Addendum No. 2

RE: Contract # C204039

Polk County (I-4729A)

I-26/US-74/NC-108 Interchange Modifications in the Town Of Columbus

PROJECT REFERENCE NO. 1-4729A	SHEET NO. RF-3
RW SHEET NO.	
ROADWAY DESIGN ENGINEER	HYDRAULICS ENGINEER

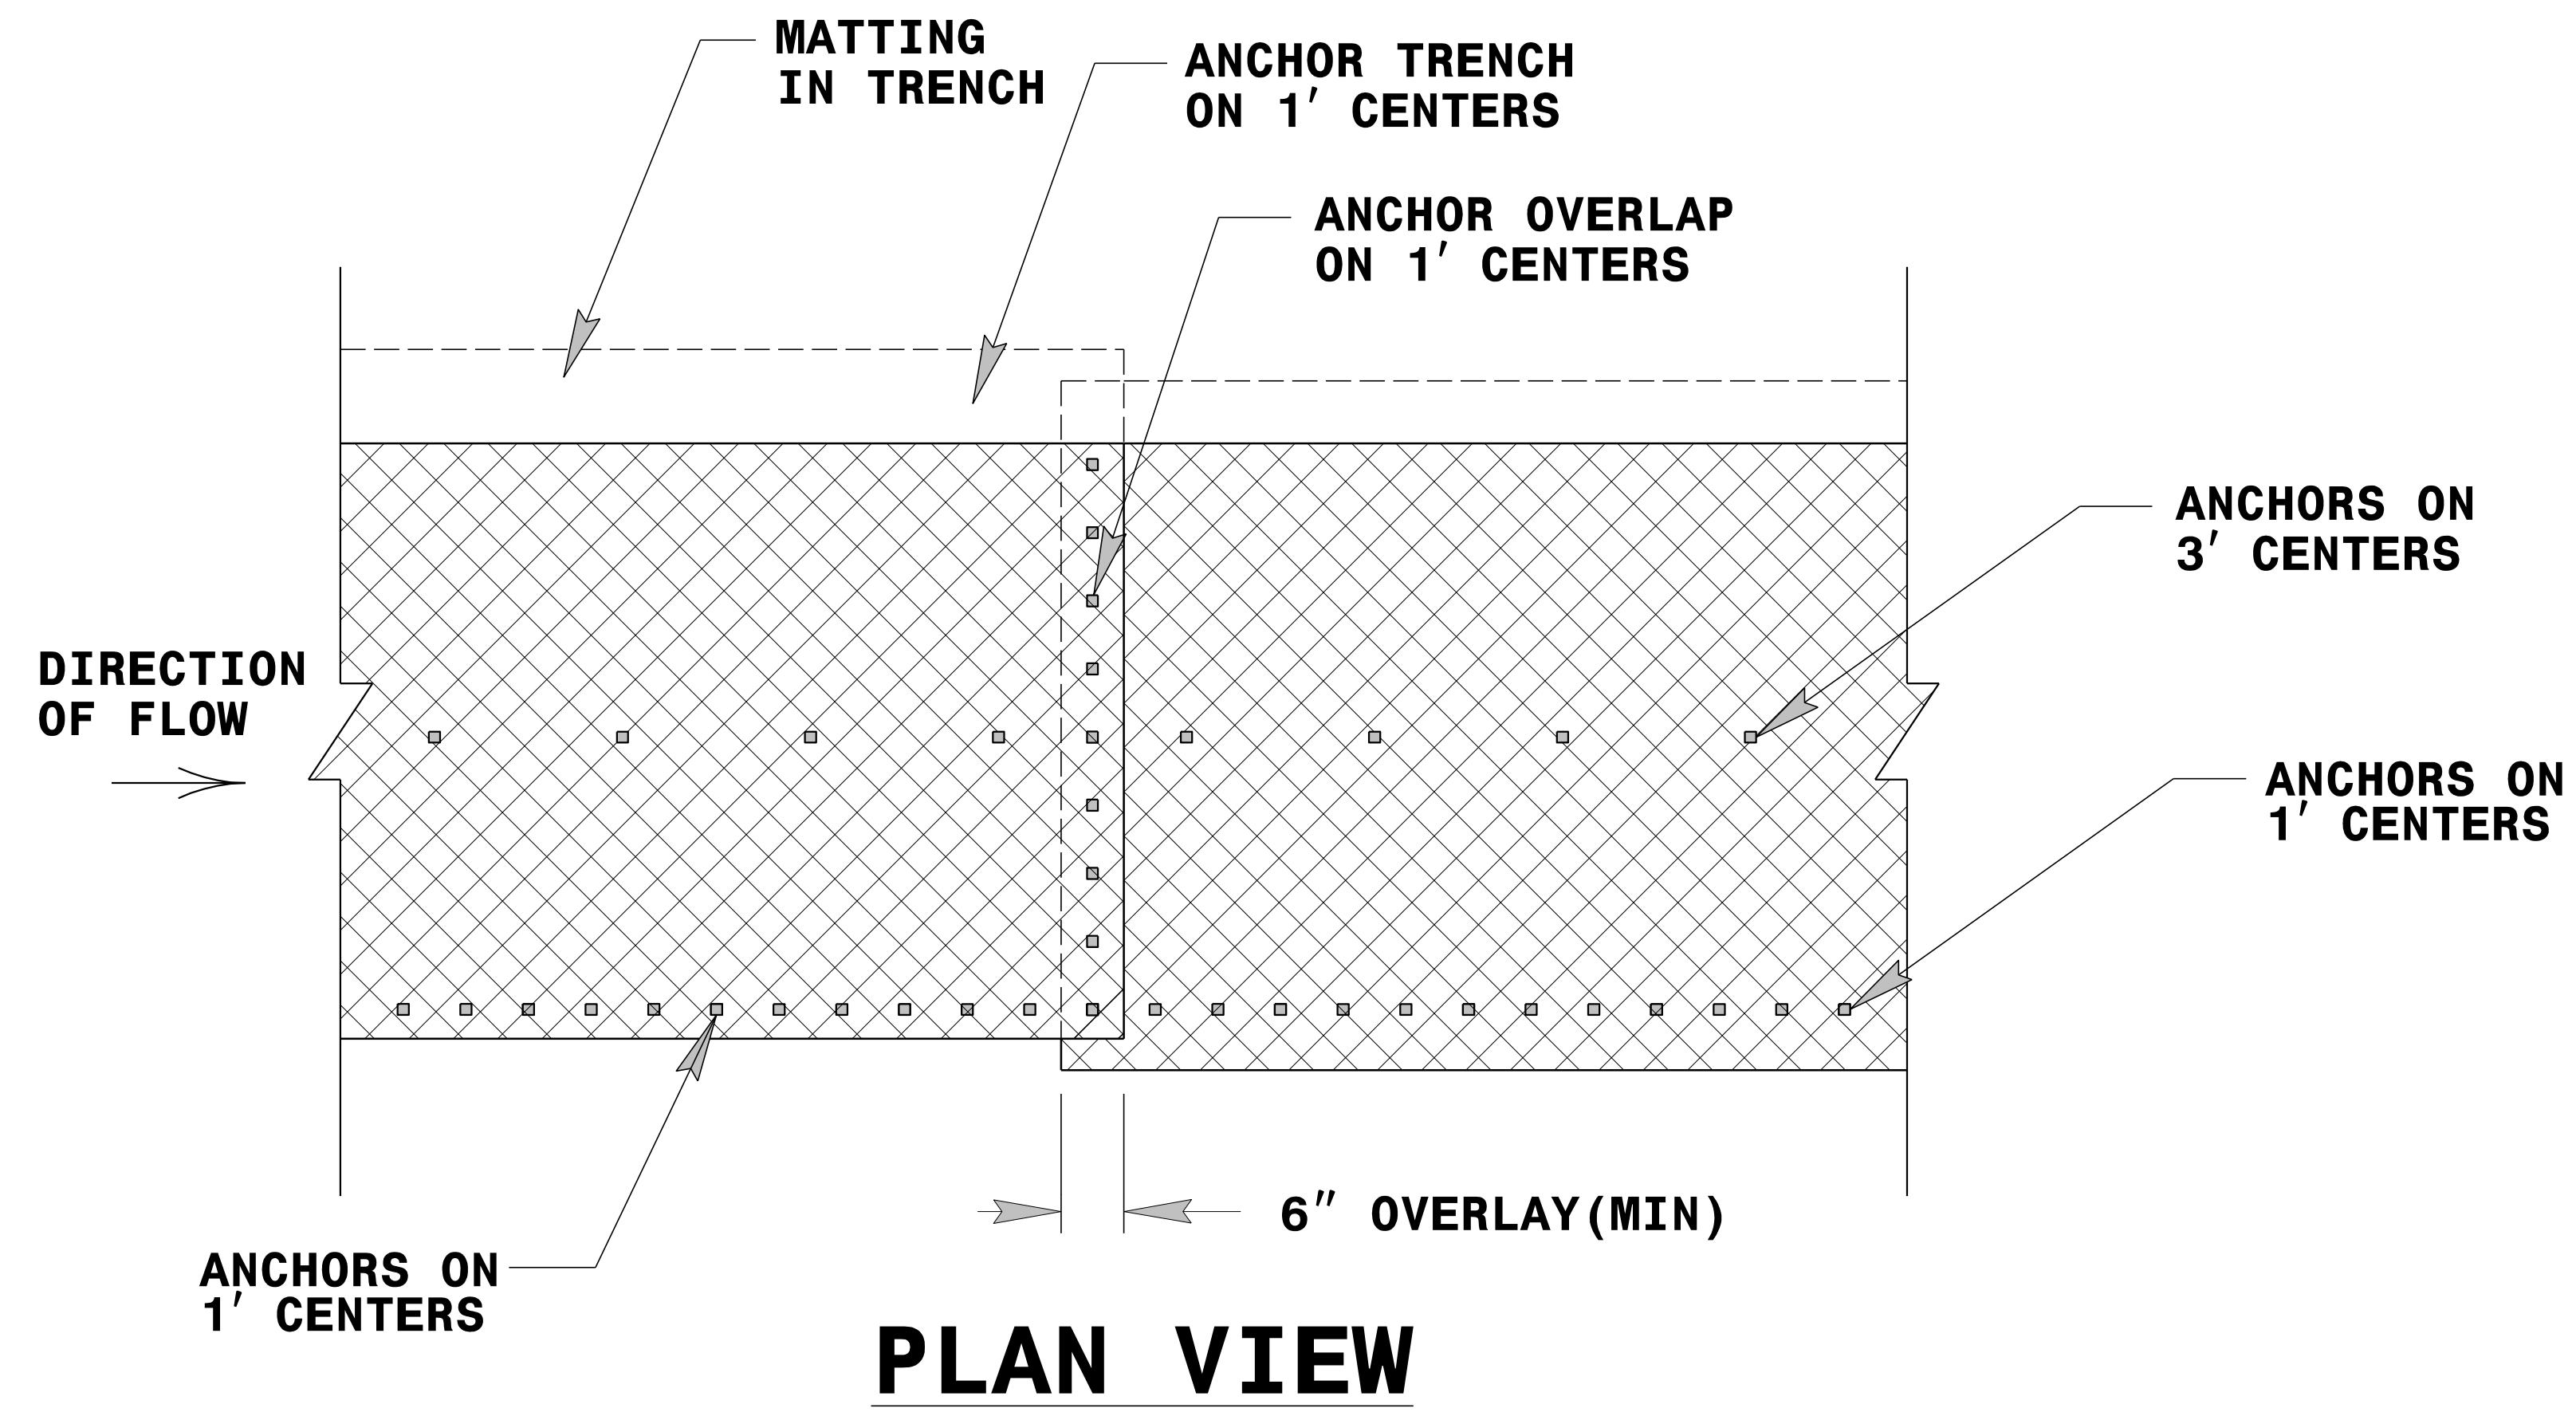
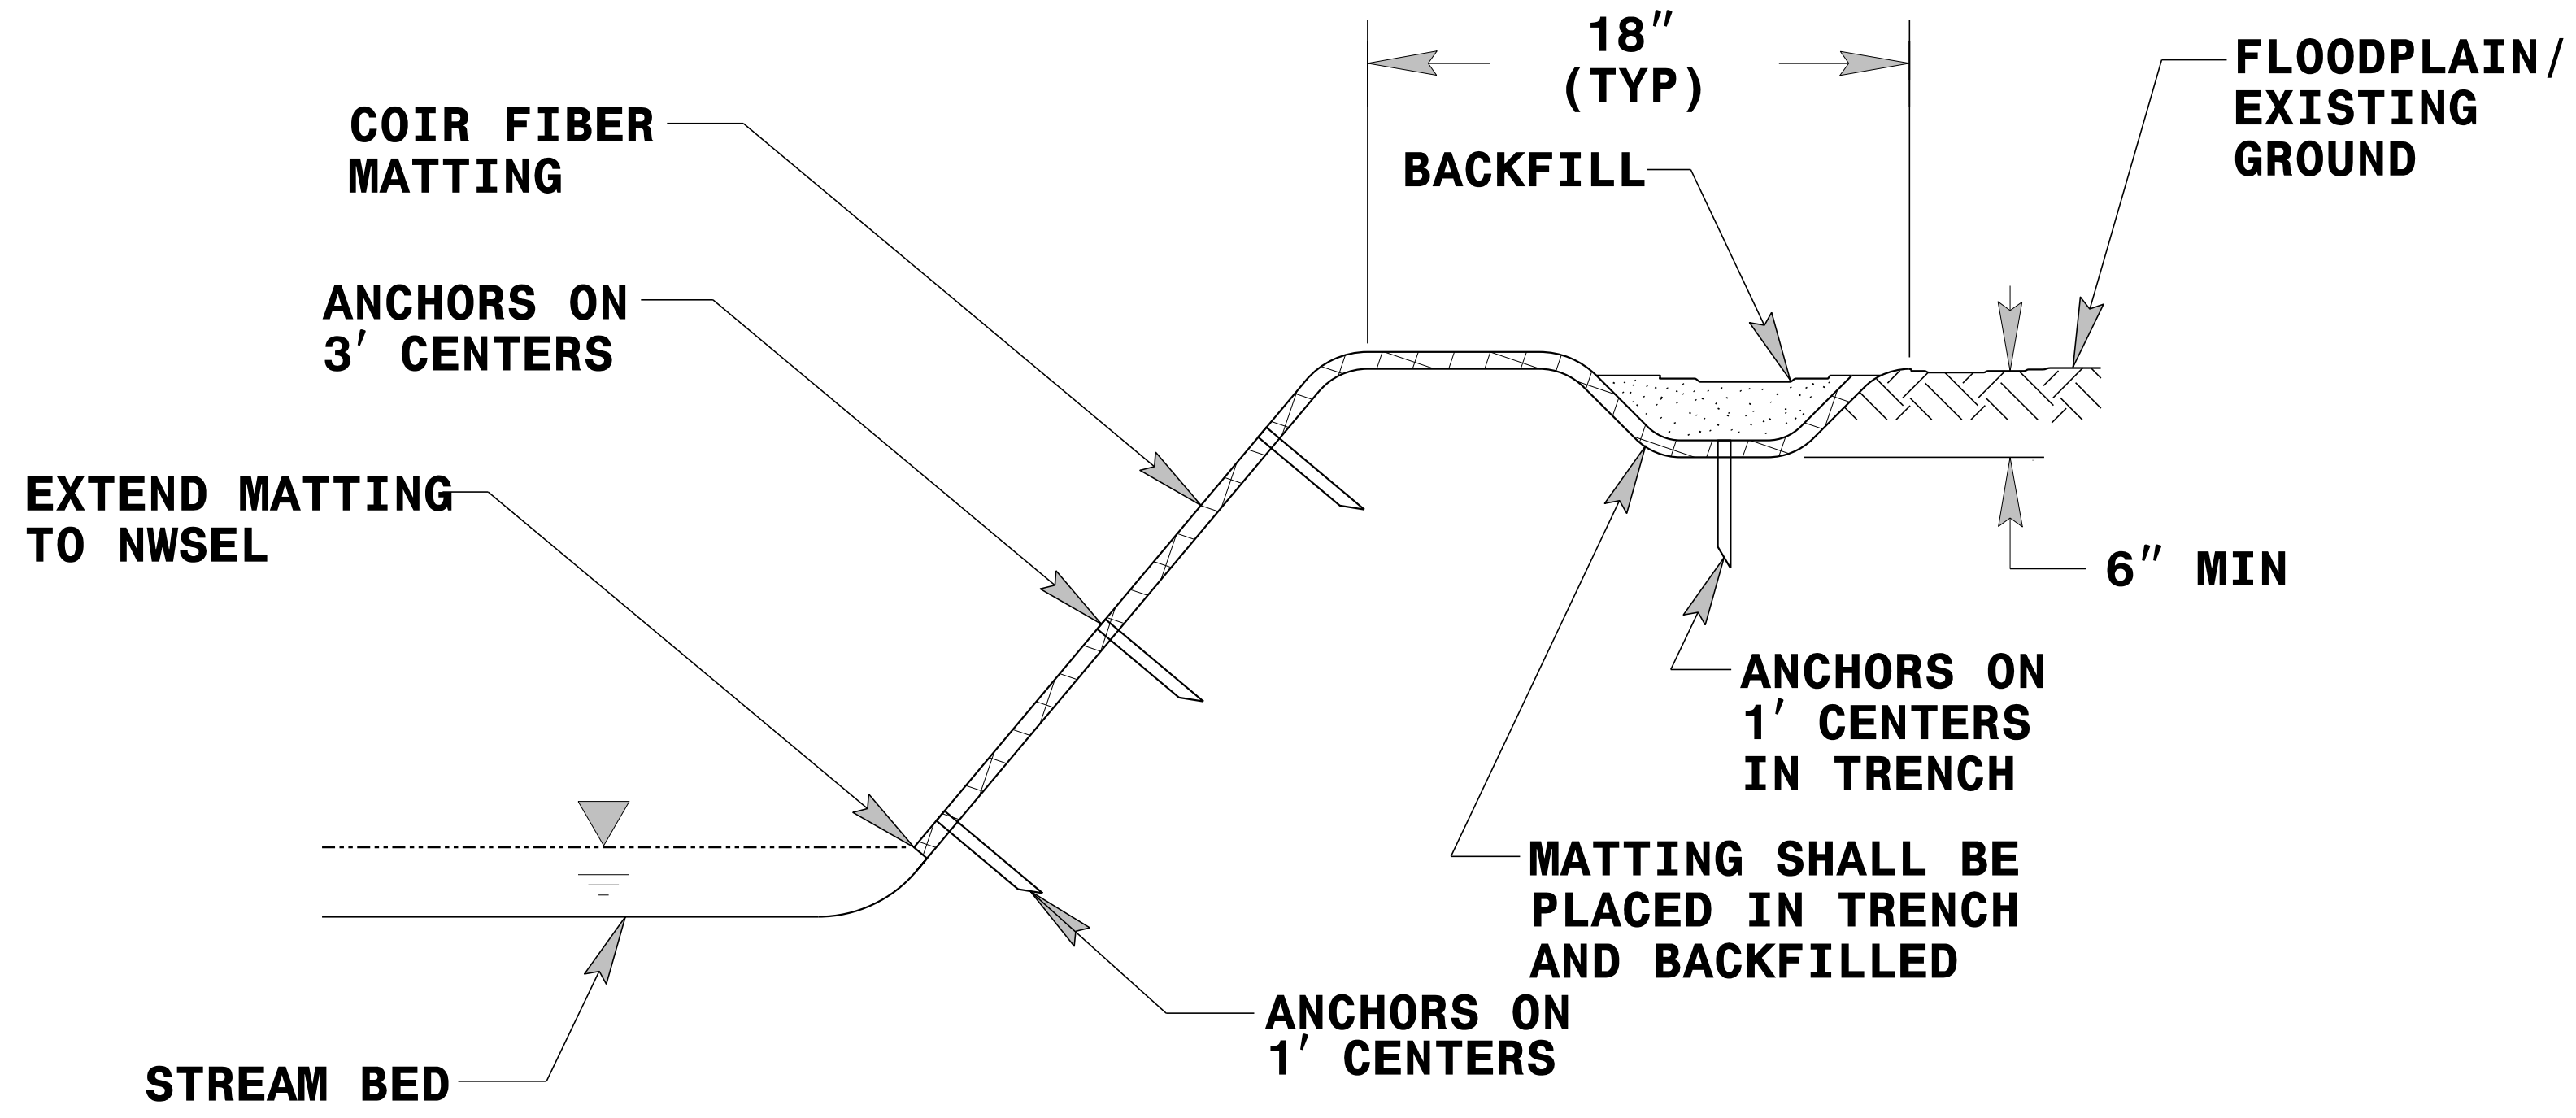
Page No.	Revisions
Proposal Cover	Note added that reads "Includes Addendum No. 2 Dated 09-14-2017".
Table of Contents	Revised to add "INTERMEDIATE CONTRACT TIME NUMBER 3 AND LIQUIDATED DAMAGES" special provision
G-2 thru G-5	Special Provision added entitled "INTERMEDIATE CONTRACT TIME NUMBER 3 AND LIQUIDATED DAMAGES"
EC-22	Special Provision added entitled "STREAM CHANNEL RELOCATION WORK"

The Contractor performing the stream relocation work on this project shall be on NCDOT's Approved Pre-Qualified List for Stream Restoration and Construction (Work Code 1601).

STREAM CHANNEL RELOCATION LIMITATIONS:

The following sequence of construction shall be followed in the areas designated on the plans as stream relocations. Failure on the part of the Contractor to follow this sequence, and complete each step prior to proceeding in this area as specified, will be just cause for the Engineer to direct the suspension of work in accordance with Article 108-7 of the *Standard Specifications*.

- (A) Clear, but do not grub area within the Environmentally Sensitive Area on the existing stream to be relocated.
- (B) Construct and stabilize, with vegetation or erosion control materials sufficient to restrain erosion, the proposed stream channel relocation as shown on the plans.
- (C) Divert water into newly constructed channel only after it has been stabilized and approved.
- (D) Begin grubbing and/or grading within the Environmentally Sensitive Area of the existing stream.

The Contractor shall perform seeding and mulching and install erosion control matting to all cut/fill slopes adjacent to stream relocations in accordance with the contract.

The above requirements apply to the stream channels being constructed at the following stations:

Approx. Sta. 12+00 to 20+15 -RP_E- RT
